The following comments were addressed:
As-Built Construction Drawings

Drainage, Grading and Erosion Control Plan

Roadway Plan

DETENTION BASIN
OUTFALL

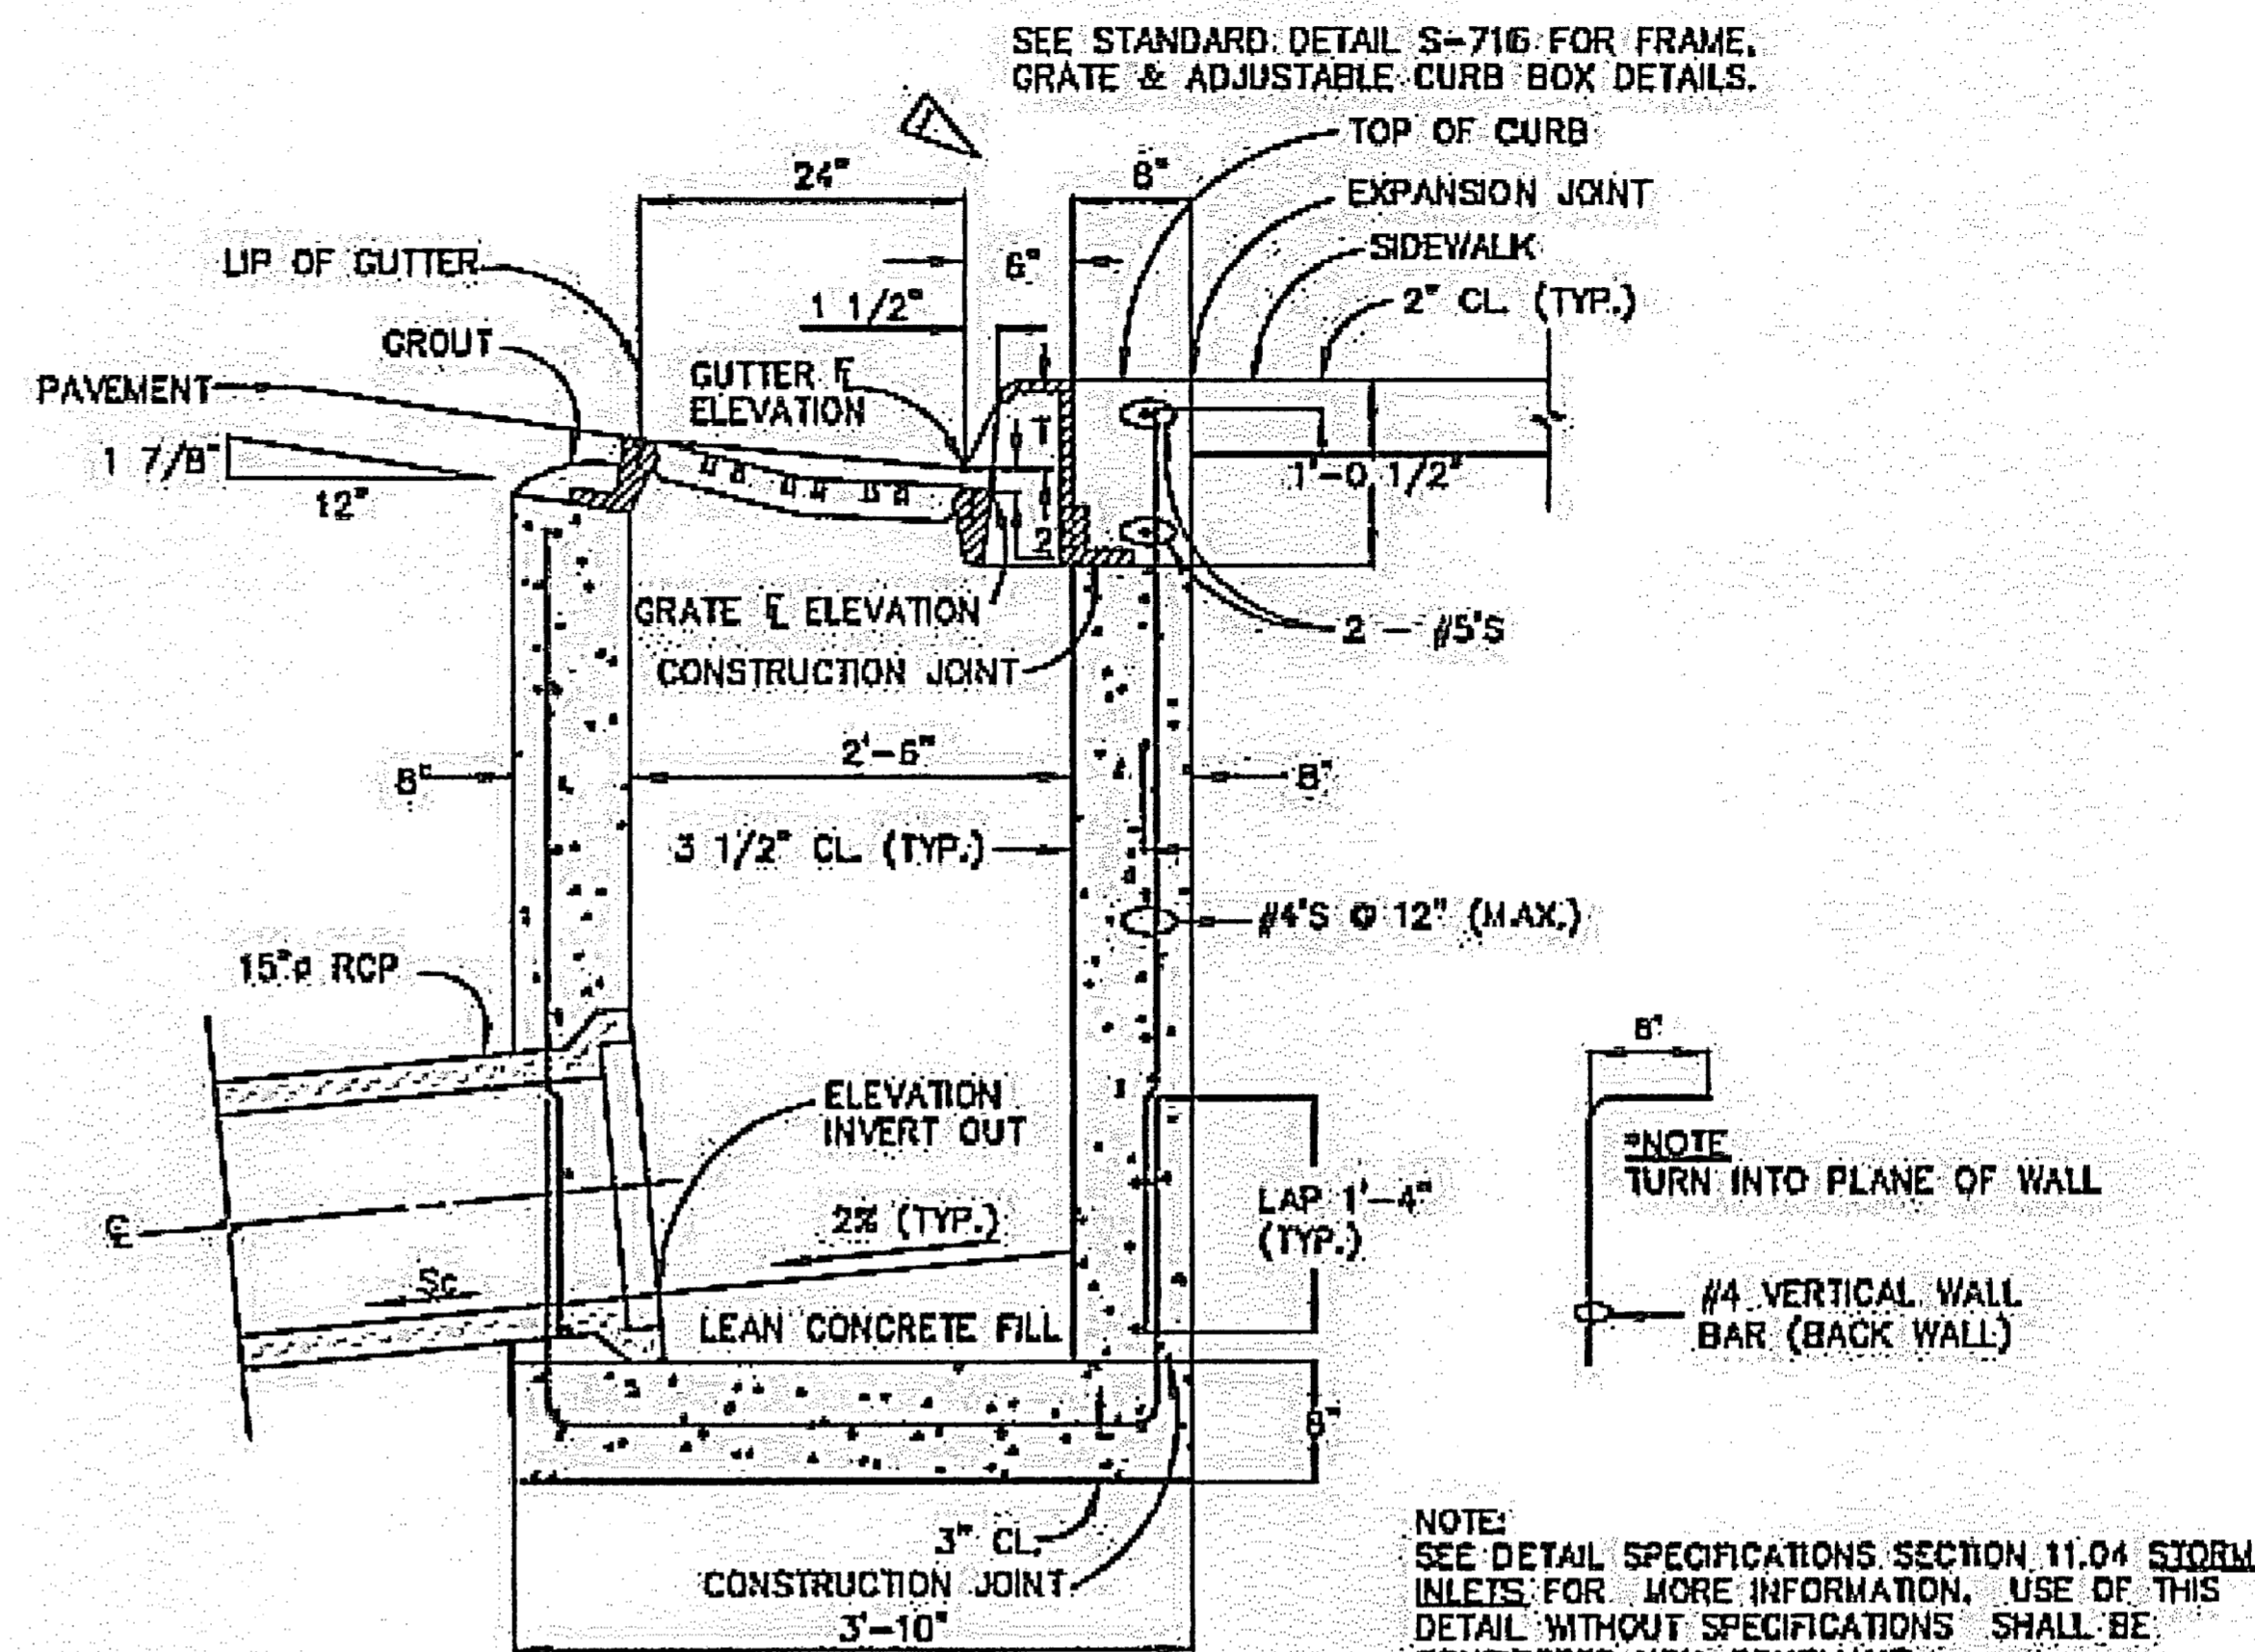
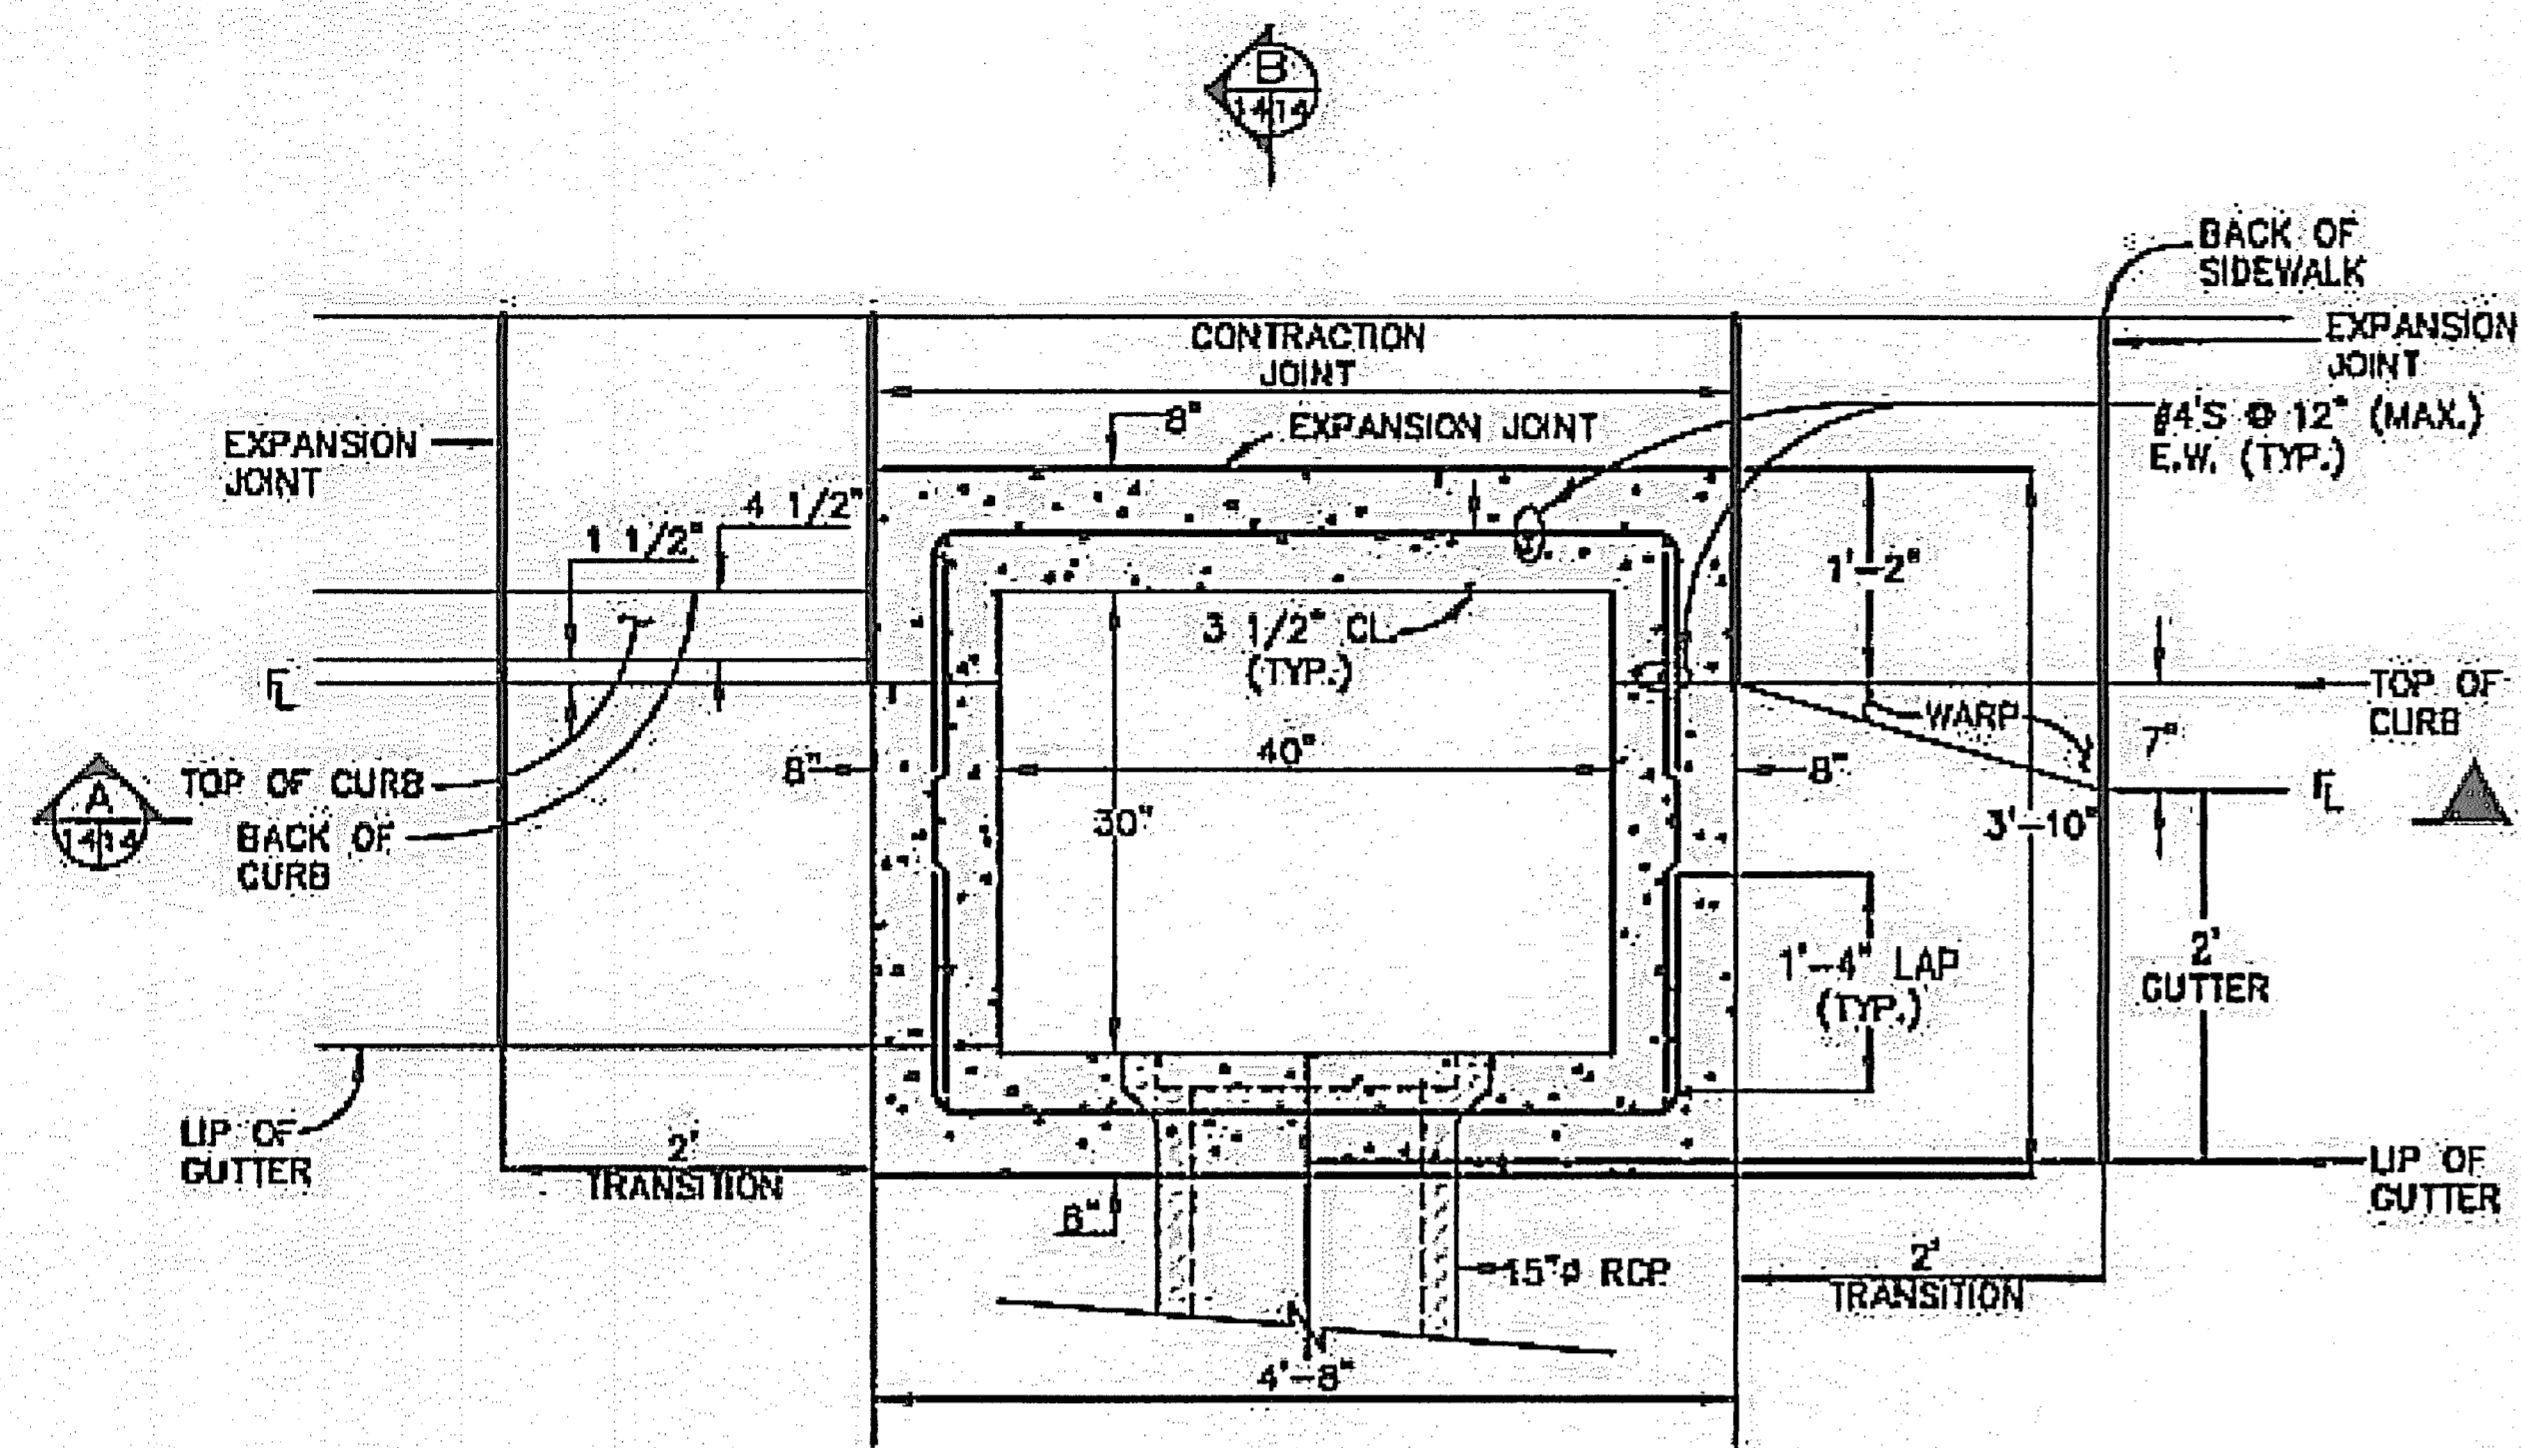
Sheet 4 – Proposed 5'x10 Riprap pad replaced by existing concrete channel at end of Detention Basin outfall.
